# KITTITAS COUNTY FIRE MARSHAL'S OFFICE

Re: Dewalt (BL-12-00006)

After conducting a review of the above named project, I have the following comments:

PART OF THE SOUTHWEST QUARTER OF SECTION 28,
TOWNSHIP 20 NORTH, RANGE 17 EAST, W.M.

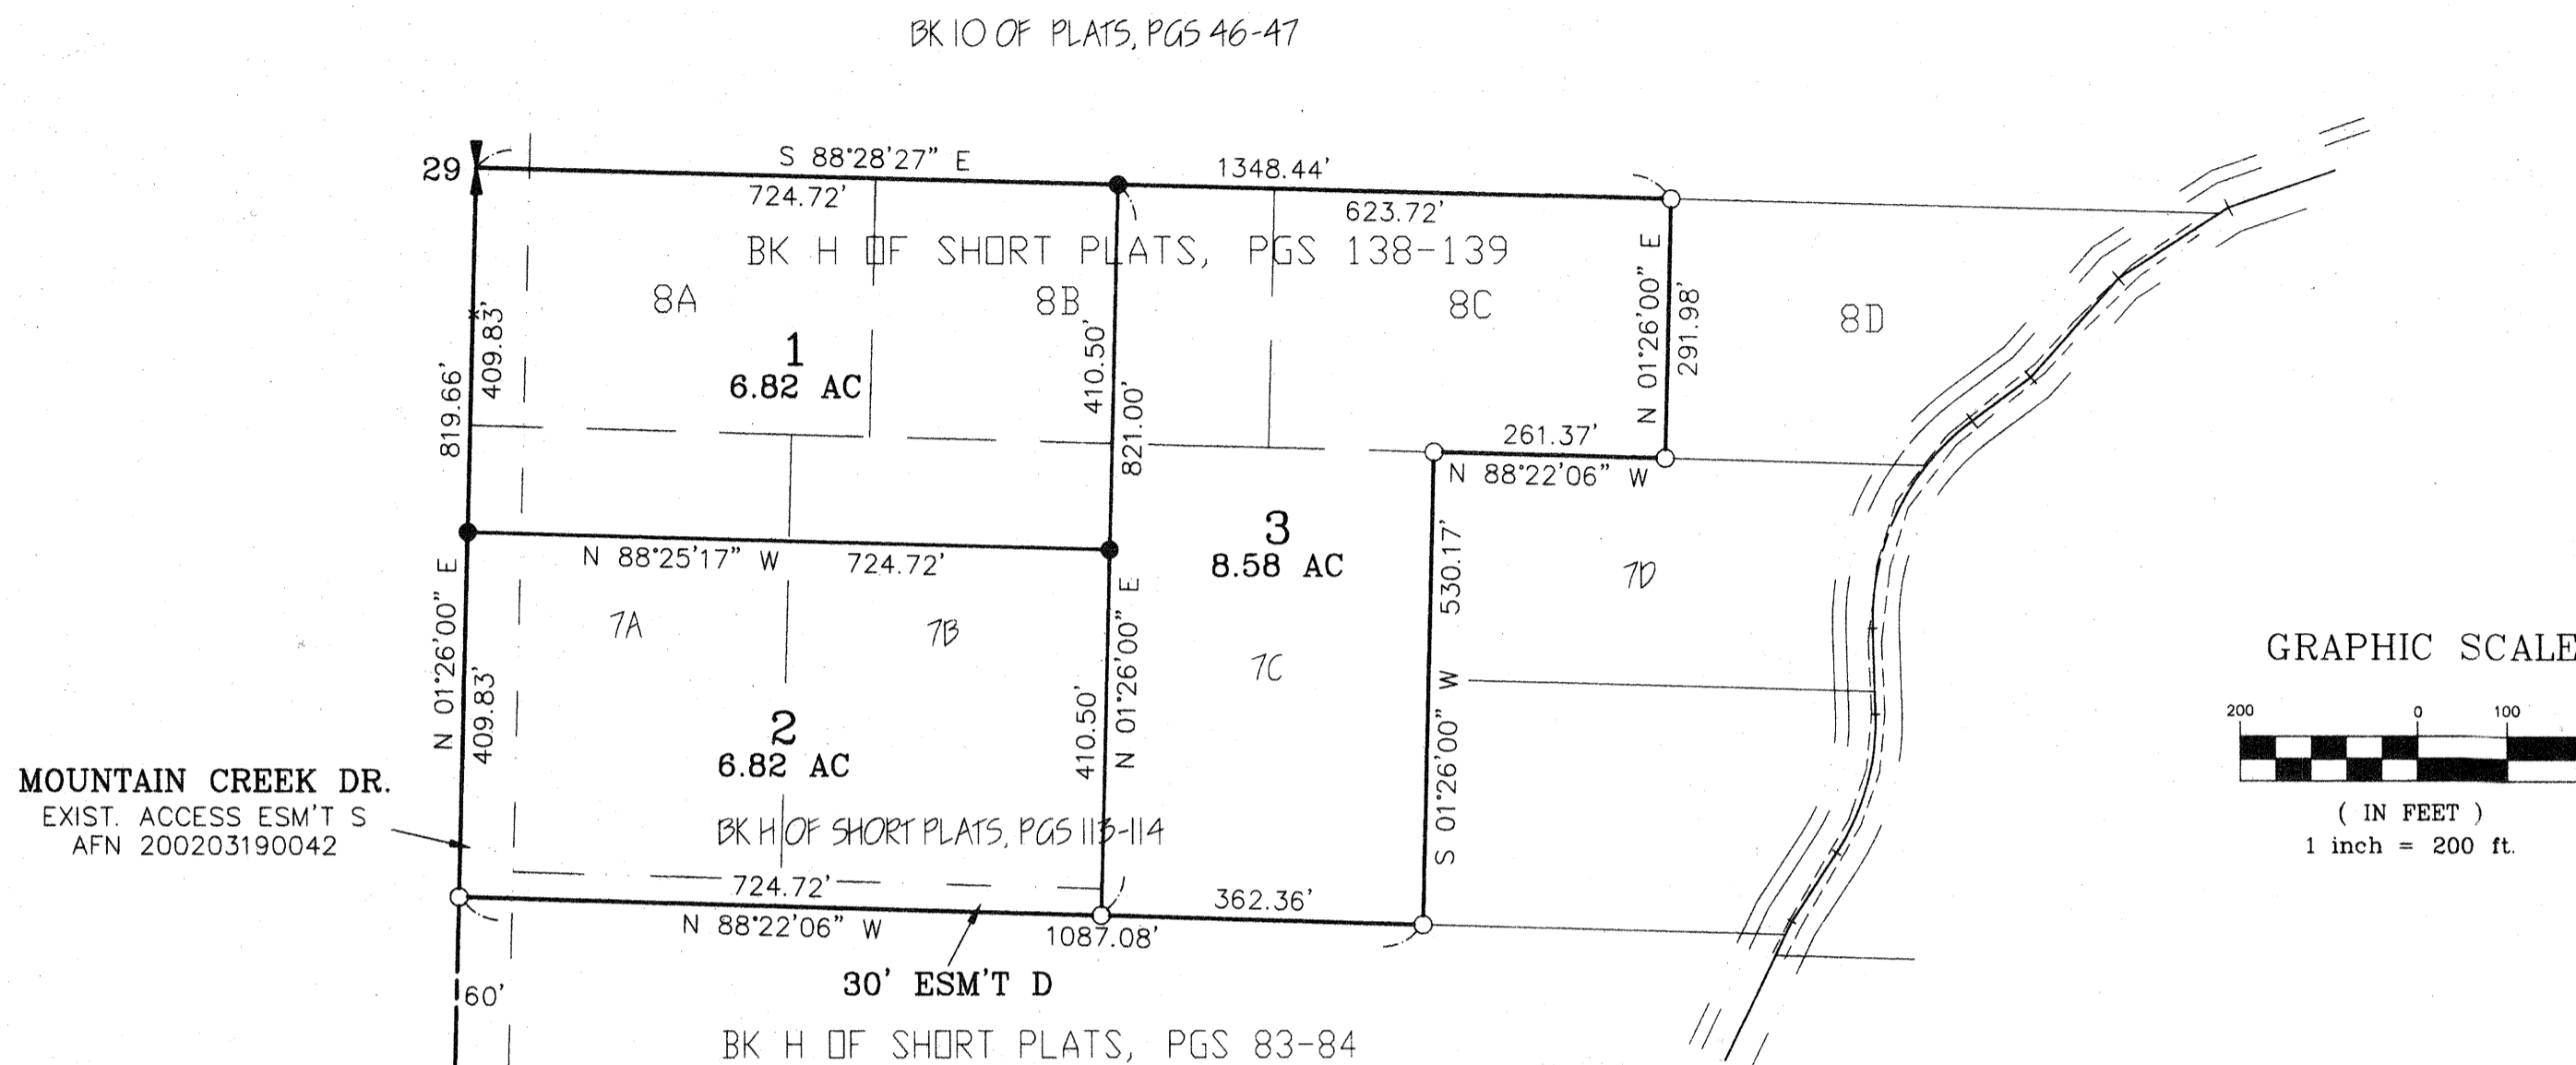
- Ensure that boundary line adjustments do not infringe upon existing structures, to include propane tanks, etc.
- Creation of any additional roads or access must comply with the International Fire Code and KCC Title 12.
- All future development must comply with the International Fire Code.
